**SITE PLAN CONTROL APPLICATION  
DELEGATED AUTHORITY REPORT  
PLANNING, REAL ESTATE AND ECONOMIC DEVELOPMENT DEPARTMENT**

Site Location: 122 Reis Road

File No.: D07-12-22-0118

This SITE PLAN CONTROL application submitted by Bridgette Alchawa, Egis, on behalf of Anthony Goveas, is **CONDITIONALLY APPROVED** subject to the acceptance of the following plans:

Drawing Title: **SITE SERVICING AND GRADING PLAN**

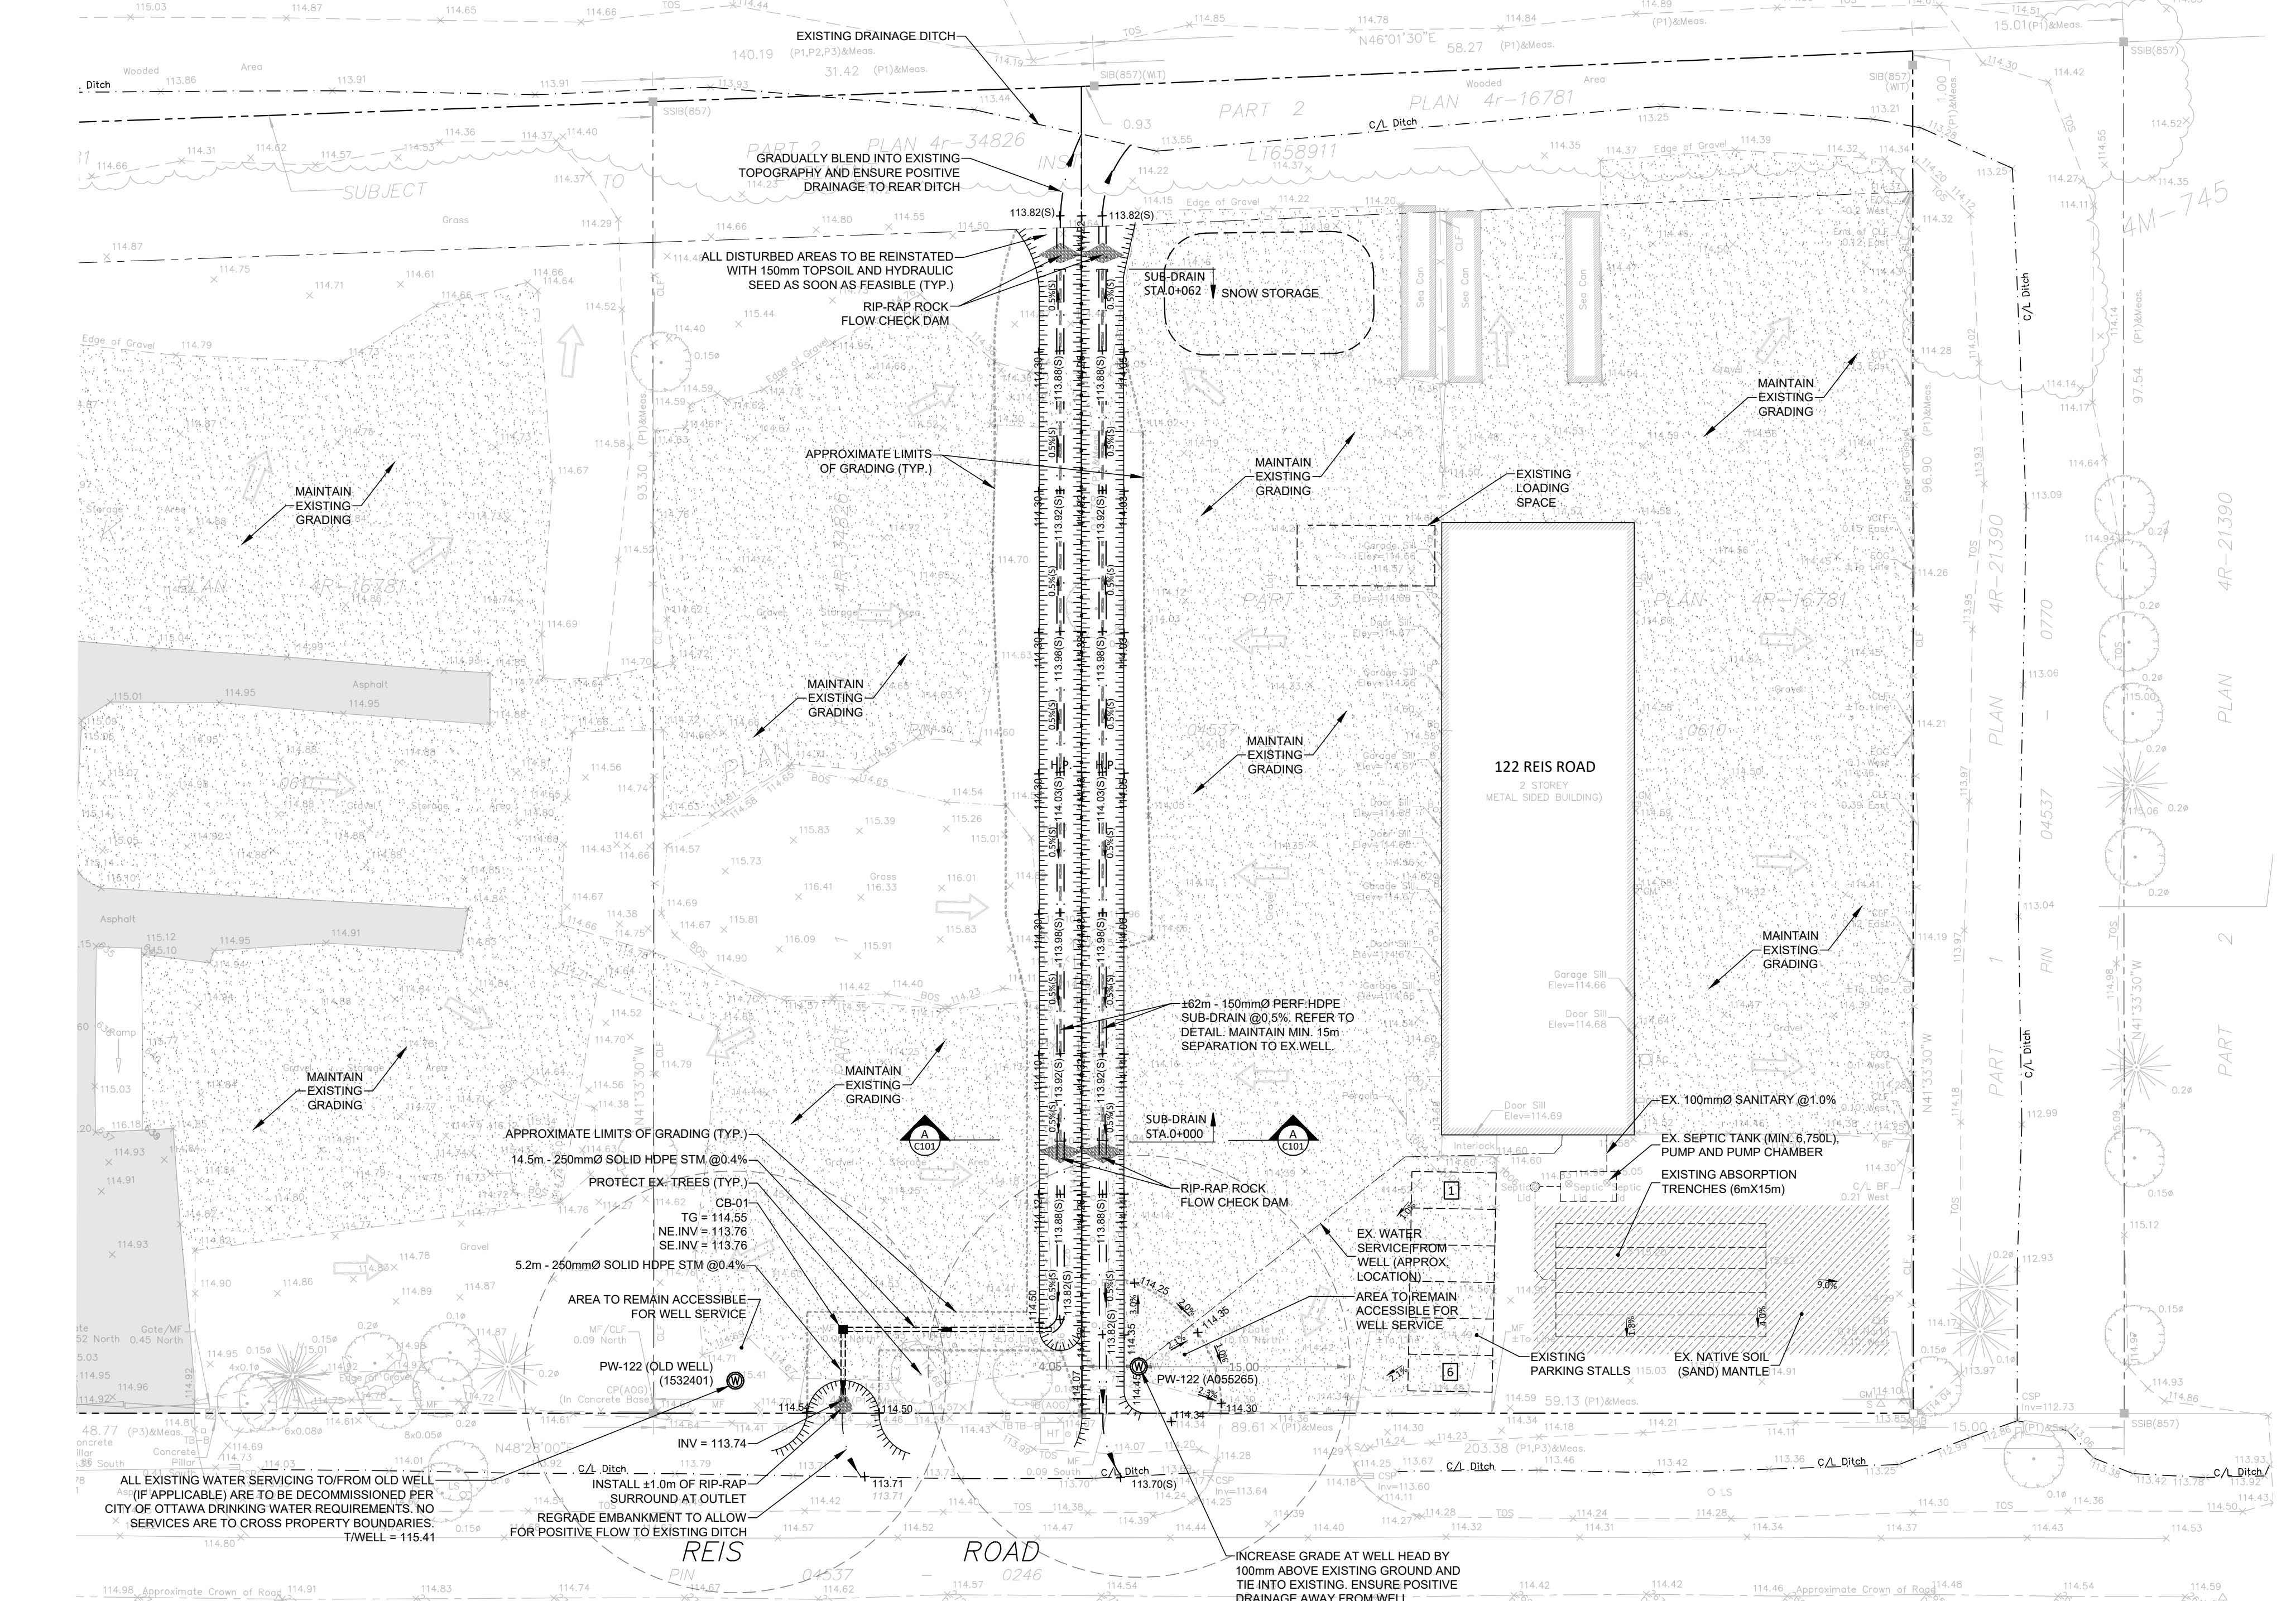
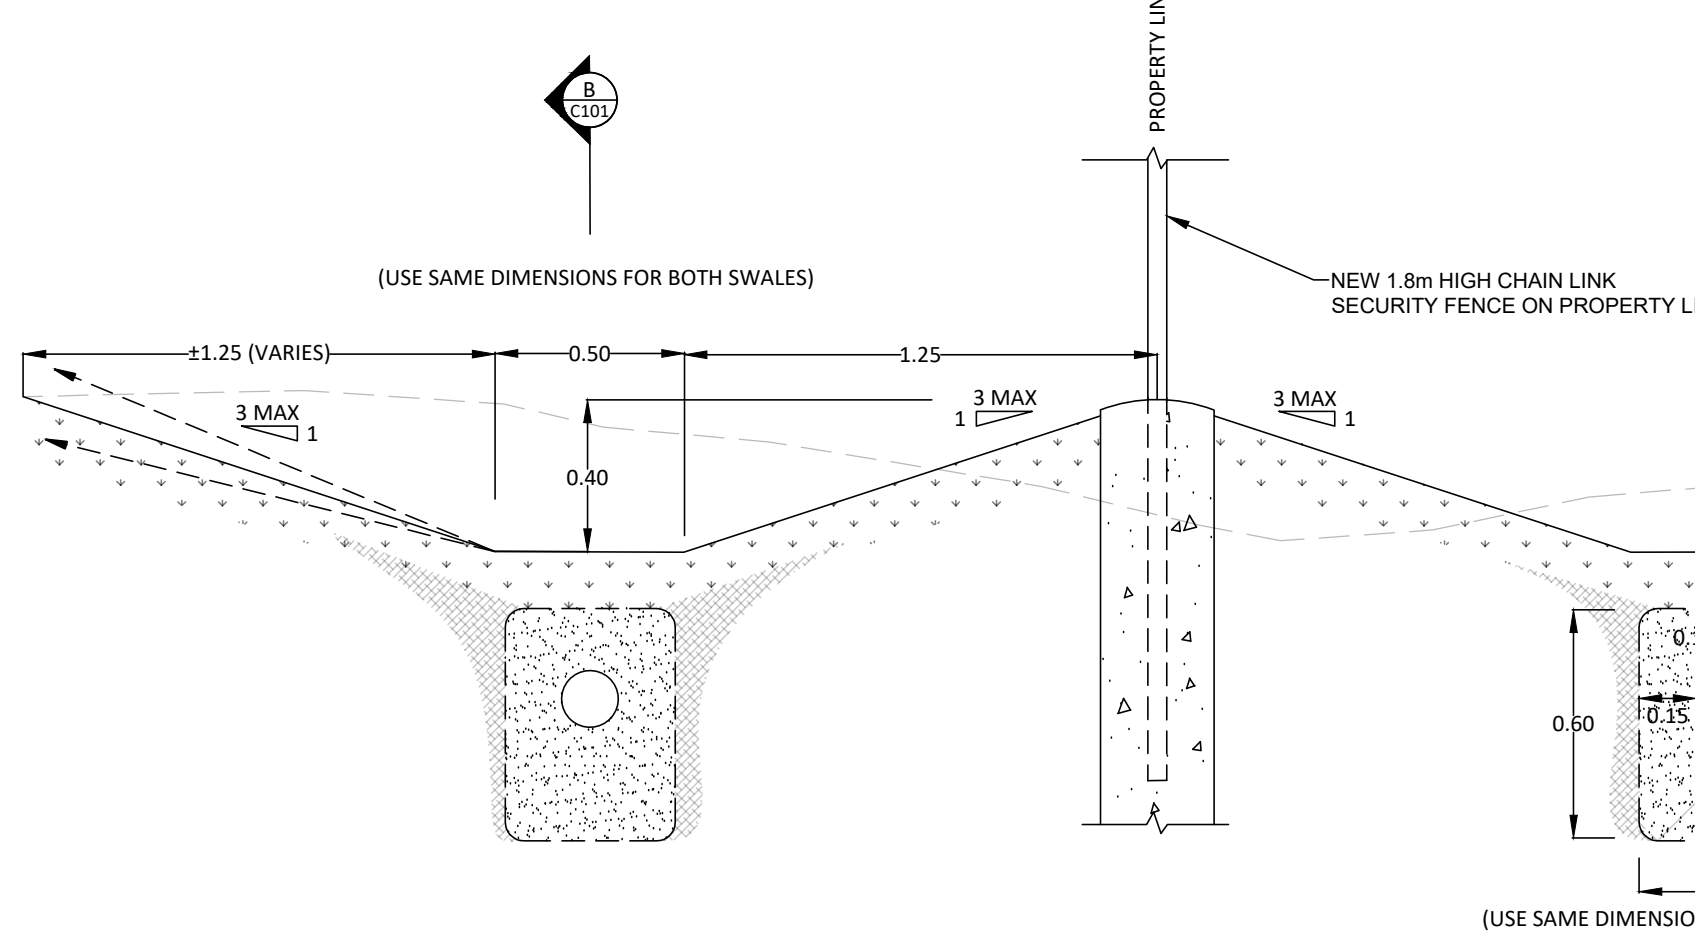
The Owner acknowledges and agrees it shall be responsible for various grading and maintenance measures along Reis Road, as a result of addition of a swale outlet to the road ROW, at the west property limit, which include the following:

- a) Coordinate the proposed work with the applicable utility companies and the property owner at 106 Reis Road;
- b) Re-grade the shoulders of the ditch within the road allowance(s) of Reis Road abutting the subject lands, to the satisfaction of the General Manager, Planning, Real Estate and Economic Development Department;
- c) Obtain utility clearances prior to the re-grading of any ditch;
- d) Obtain approval from the City's Roads Services Branch of the Public Works Department if the grade of any ditch bottom is to change; and
- e) Maintain a grass cover within the road allowance(s) of Reis Road abutting the subject lands, to the satisfaction of the General Manager, Planning, Real Estate and Economic Development Department.
